CITY OF ALBUQUERQUE

August 7, 2013

**Re: Glenrio Apartments, Tracts 223-4 Airport Unit, Grading and Drainage Plan
Engineer's Stamp dated 06-21-2013 (J-10/D043)**

GRADING PLAN

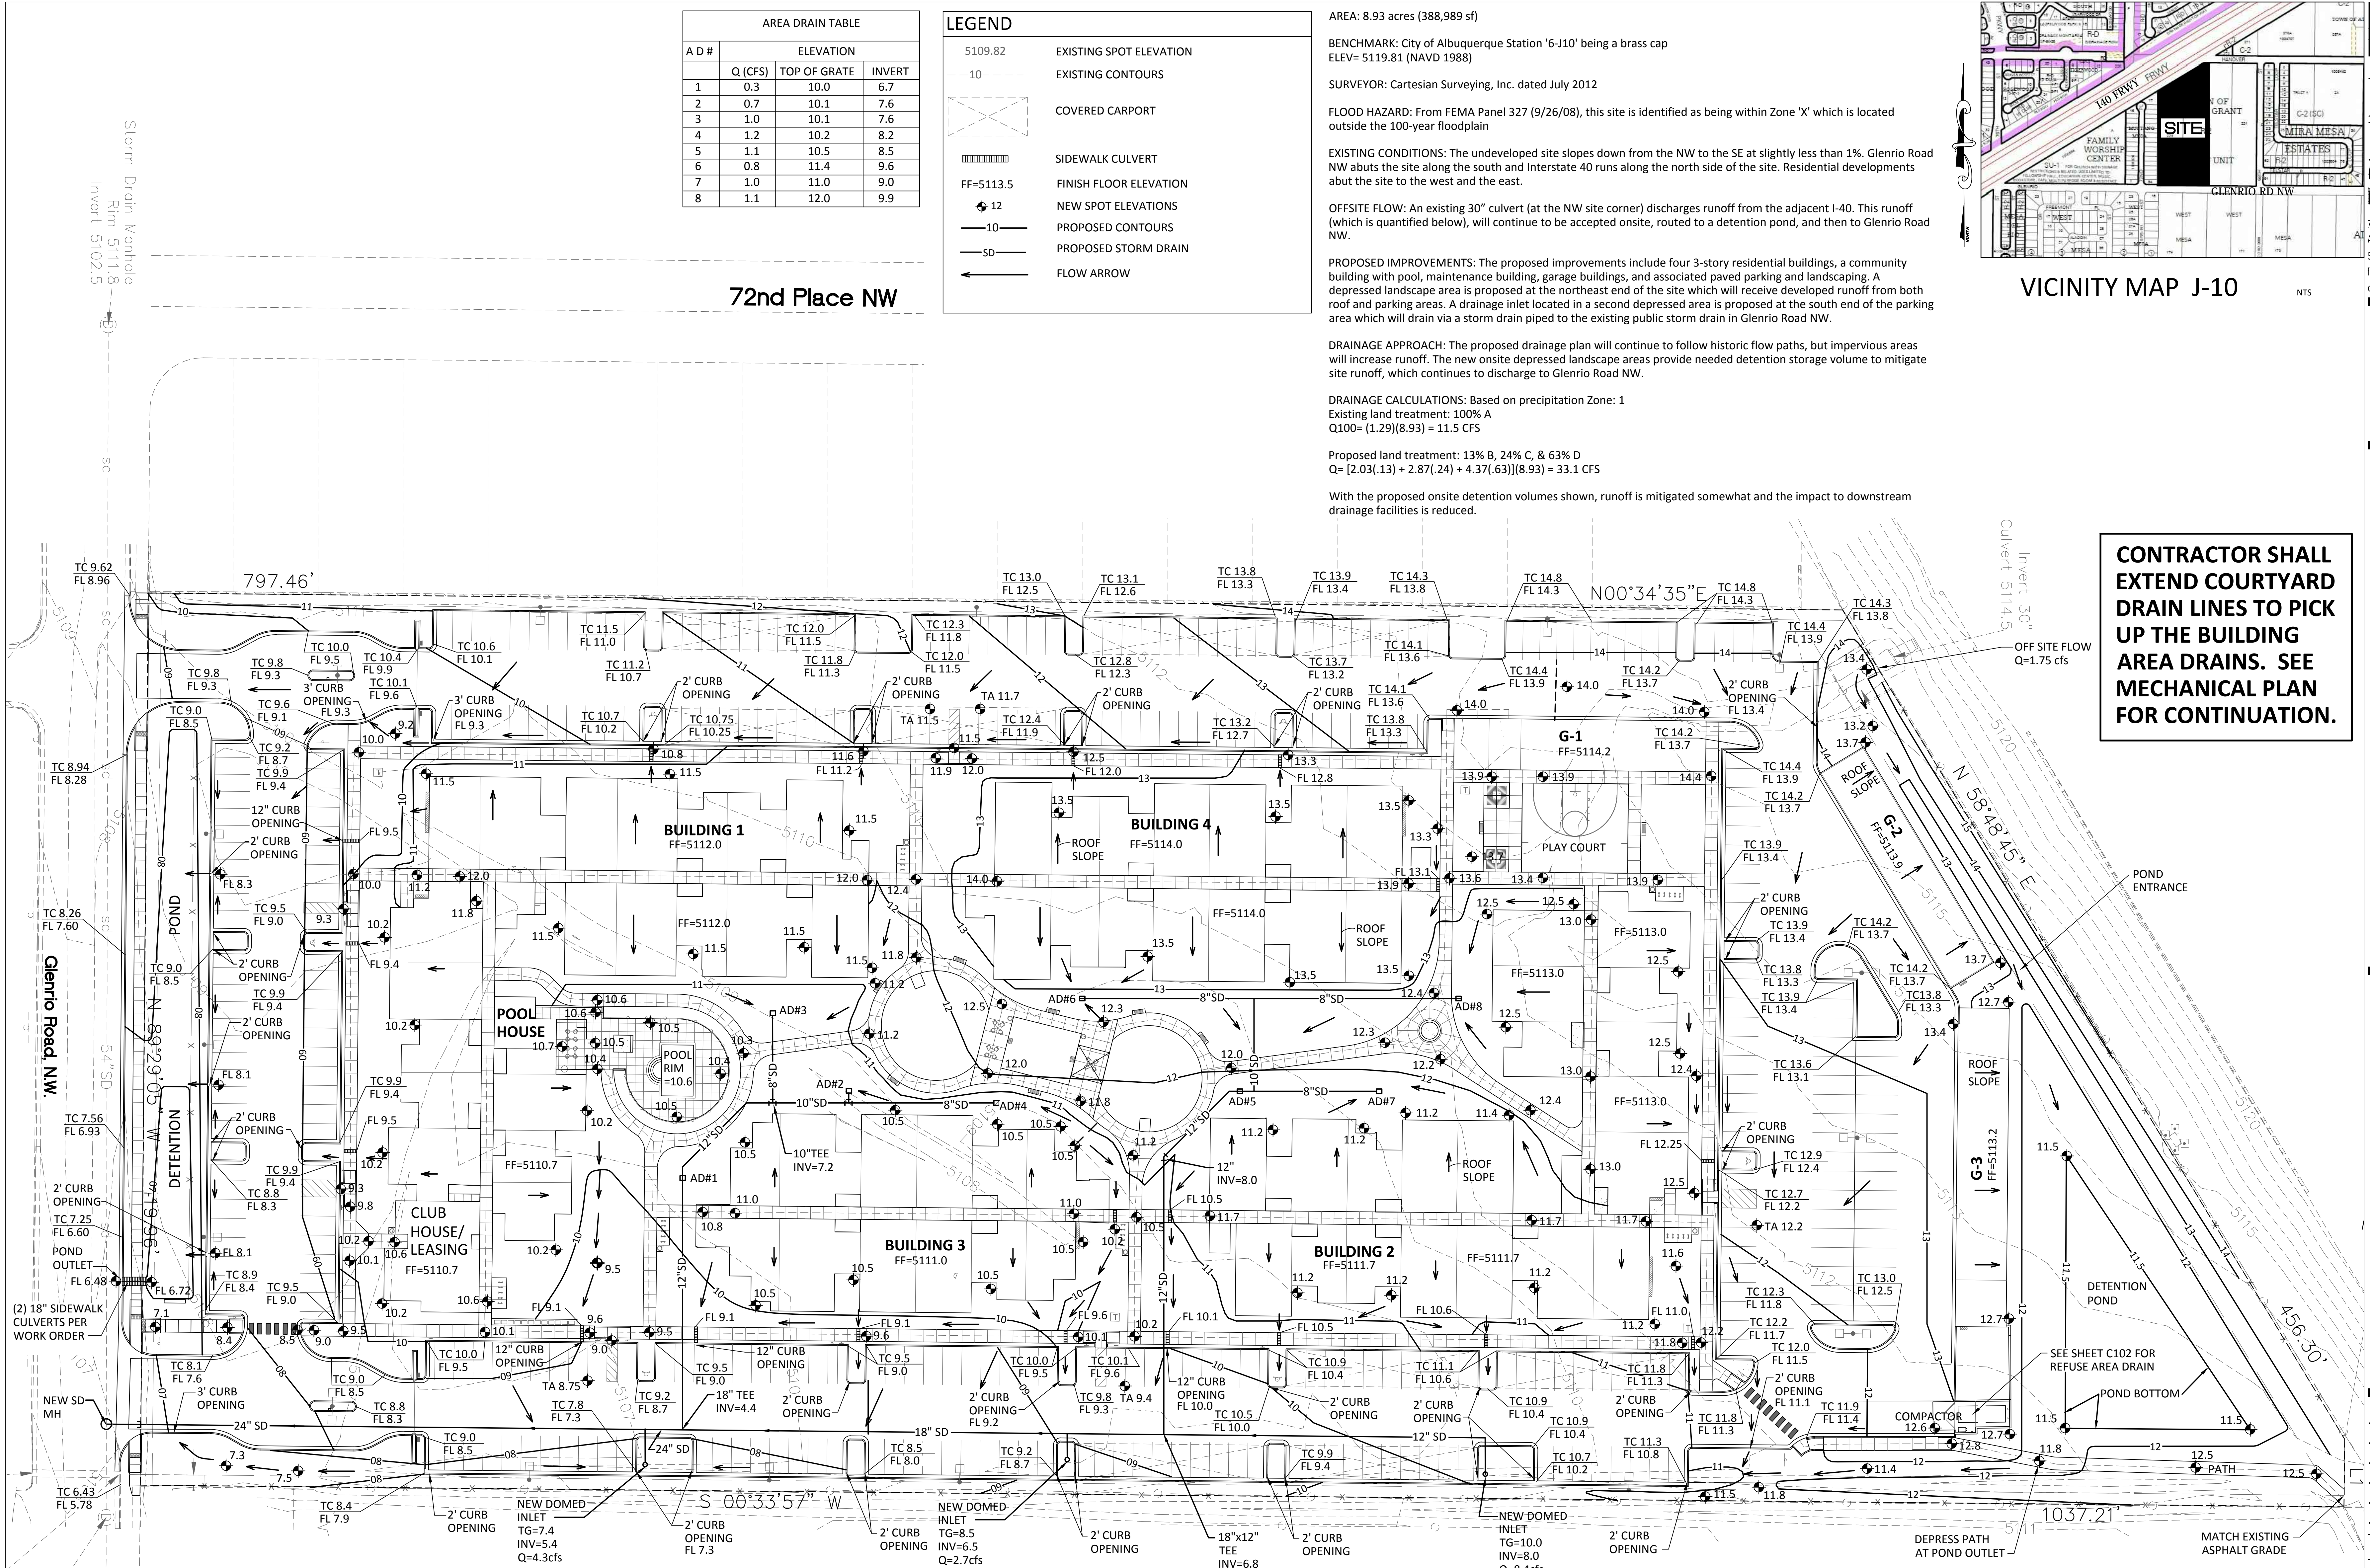
- Clearly show the property line on the grading plan.
- The previously approved grading plan for these tracts (Thompson, June 6, 2006) shows an offsite flow entering the site at a rate of 1.75 cfs; this plan indicates an offsite flow of 1.5 cfs. Please clarify the rate of this flow.

- The accompanying drainage report proposes that the offsite flows will enter a detention pond and will "likely" infiltrate or evaporate before running off. How "likely" is it for either of these processes to occur and what rate of flow will be released from the proposed detention pond into Basin C?

- The proposed storm drain manhole in Glenrio Road will need to be accomplished through Work Order. In keeping with the original intent of the drainage plan for this tract, Basin A should also drain into the proposed onsite storm drain system rather than through a sidewalk culvert.

- Clarify that all of Basin A will drain into the proposed detention pond.
- The proposed sidewalk, curb and gutter, and drive entrances will also need to be constructed under Work Order.

- No grading shall be permitted outside of the property line along the northern site boundary without obtaining prior permission from the State.
